November 17, 2020

**Re: Meineke Car Care**  
**5901 Carmel Ave NE**  
**Traffic Circulation Layout**  
Architect's Stamp 09-22-2020 (C18-D049)

Based upon the information provided in your submittal received 11-12-2020, the above referenced plan cannot be approved for Building Permit until the following comments are addressed:

SHEET NUMBER
AS-1.0

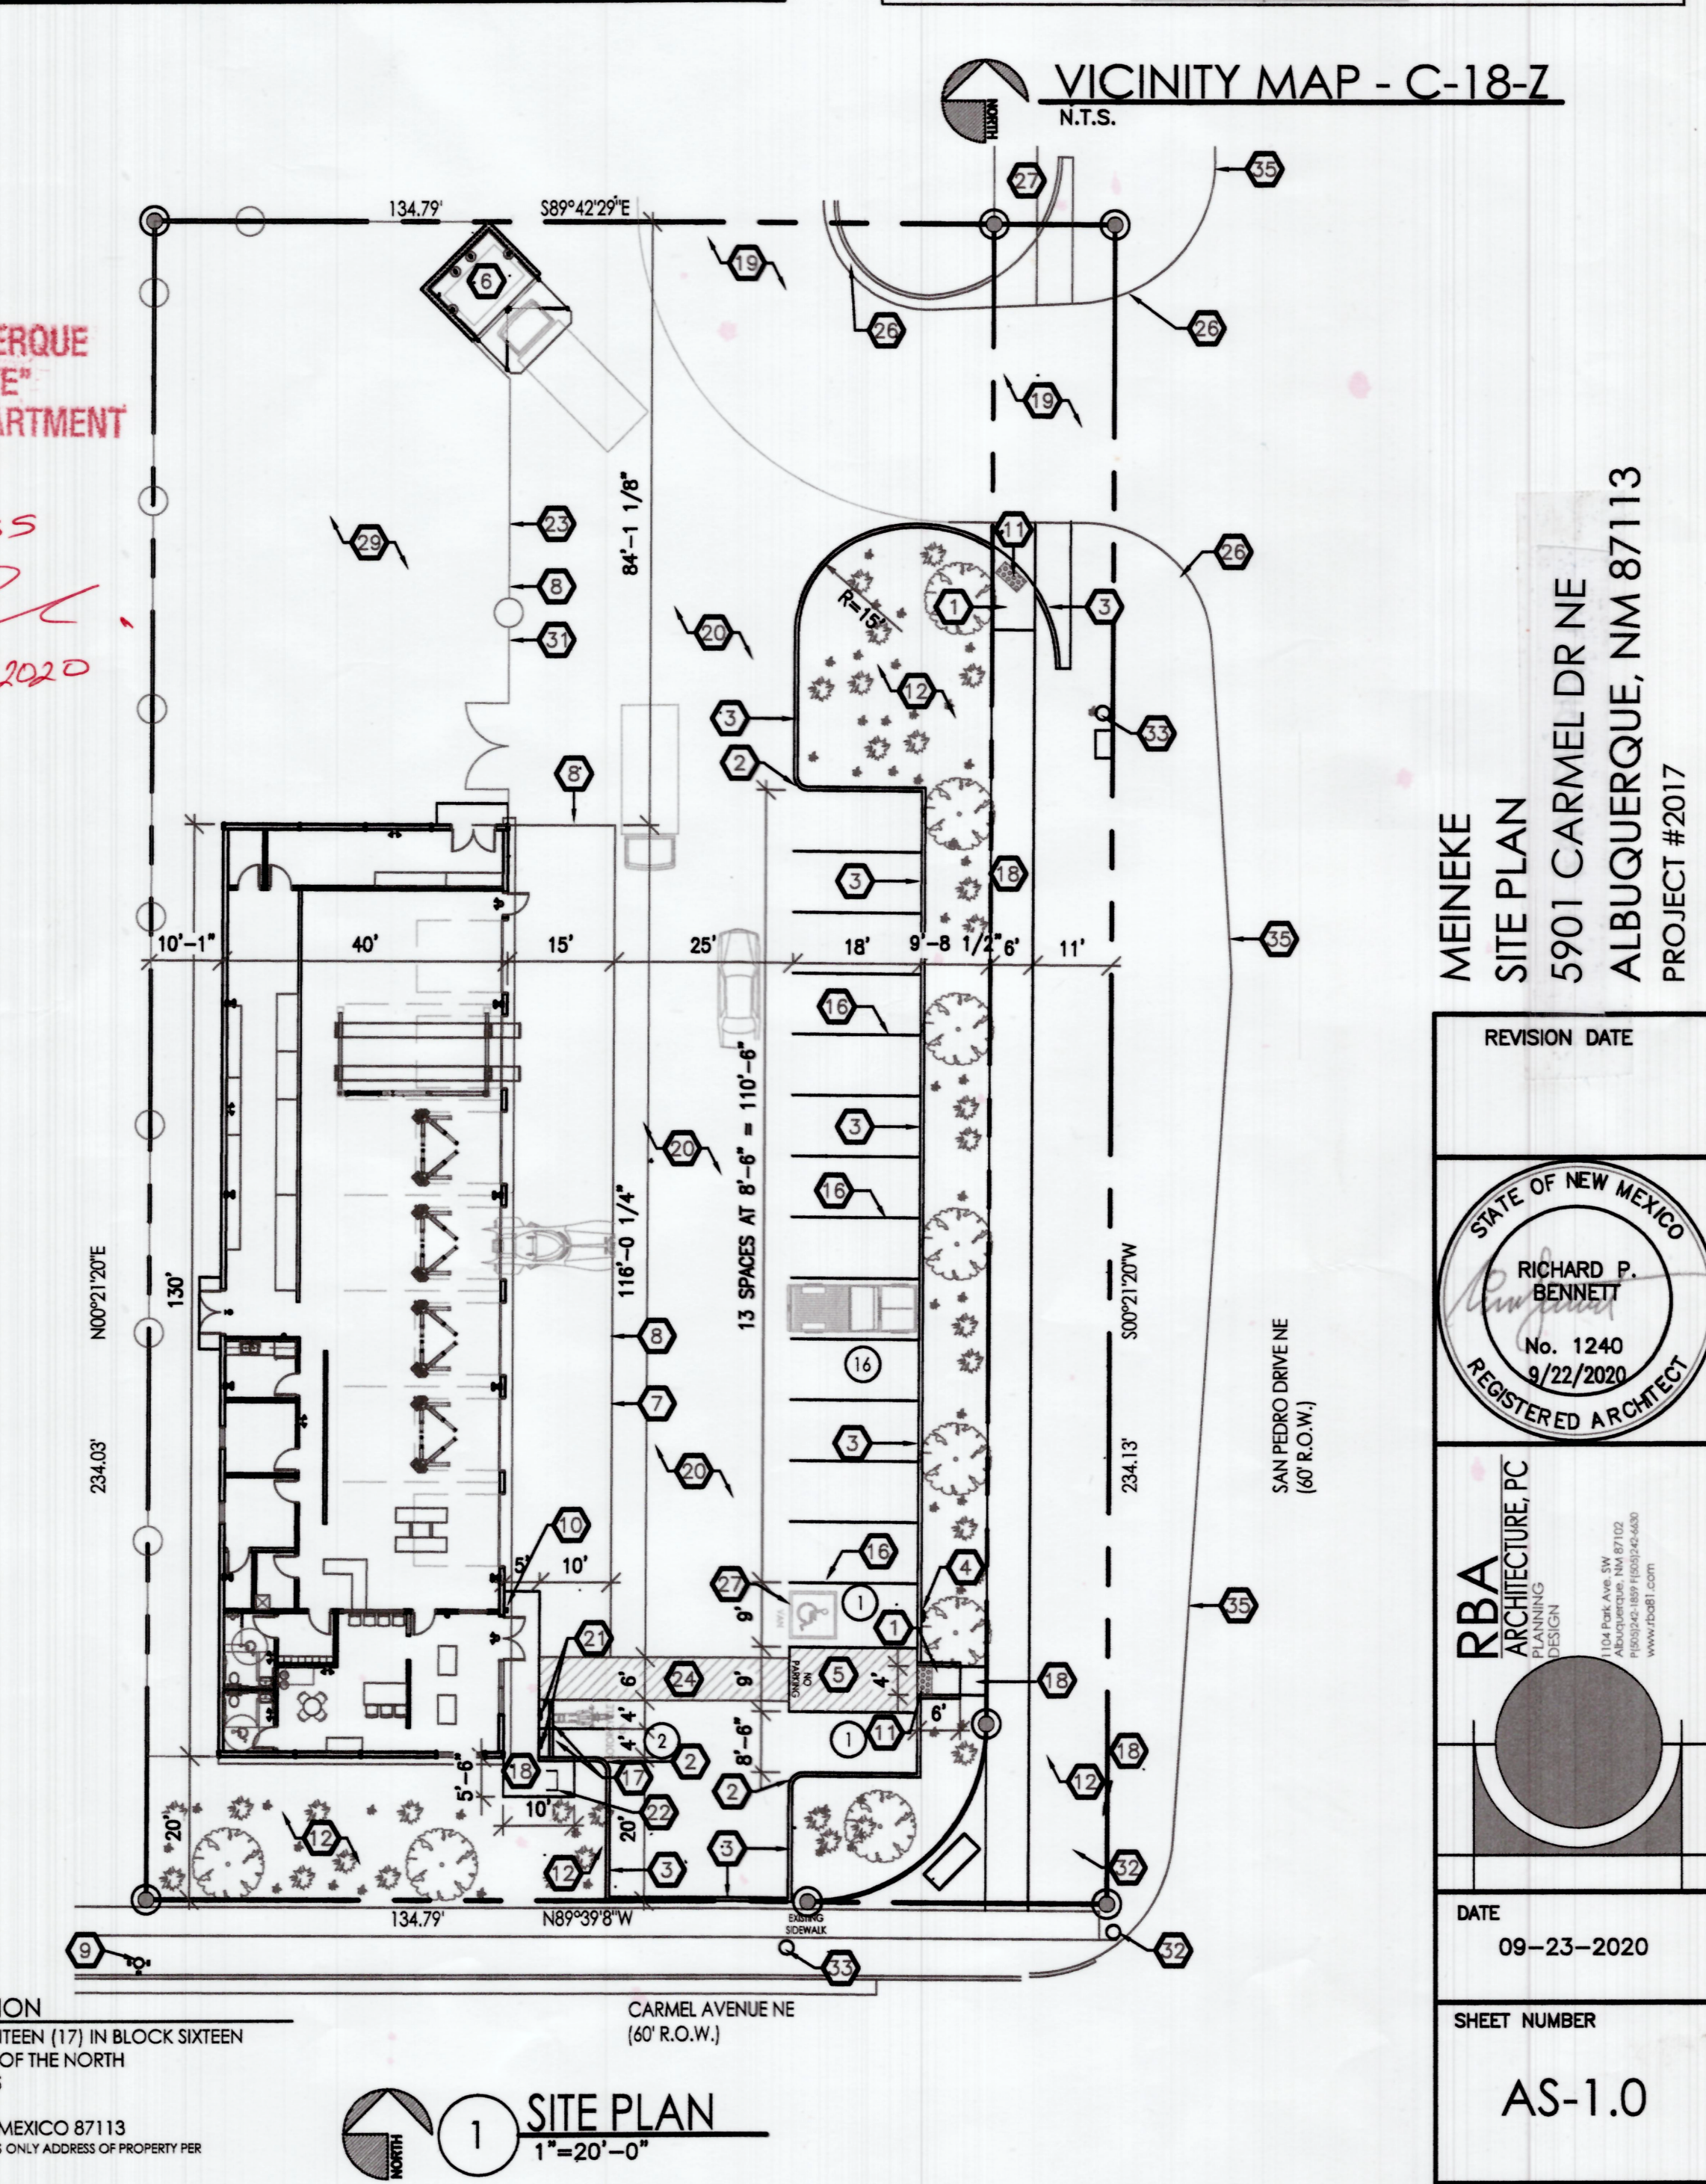
1. **All proposed infrastructure fronting San Pedro: Keyed notes will change once you have accomplished ROW dedication at DRB. So, please adjust notes until final decision has been established at DRB.**

2. Show all radii. Some are not shown.
3. 6 ft. wide sidewalk connection ADA ramp will need a detail provide on plans.
4. Per DPM, a 6 ft. wide ADA accessible pedestrian pathway is required from the ADA parking stall access aisles to the building entrances. Please clearly show this pathway and provide details. It appears that you only have 5 ft width fronting building entrance.

5. Please provide a intersection sight distance exhibit at Carmel from the proposed landscaping fronting San Pedro.
6. All references to detail will need to be provided.

7. **Shared Site access: driveways that straddle property lines, or are entirely on one property but are to be used by another property, shall have an access easement. Please include a copy of your shared access agreement with the adjacent property owner.**

8. Keyed Notes referencing sign will need details provided. Especially sheet AS-5.0. Not all signage (Monument) has been provided.
9. Keyed Note 7: Why are you proposing Fire lane by the San Pedro entrance? Please clarify what you are trying to accomplish.

10. Keyed Note 1: You call out COA std dwg 2446. Please adjust to 2426, since there is no 2446.
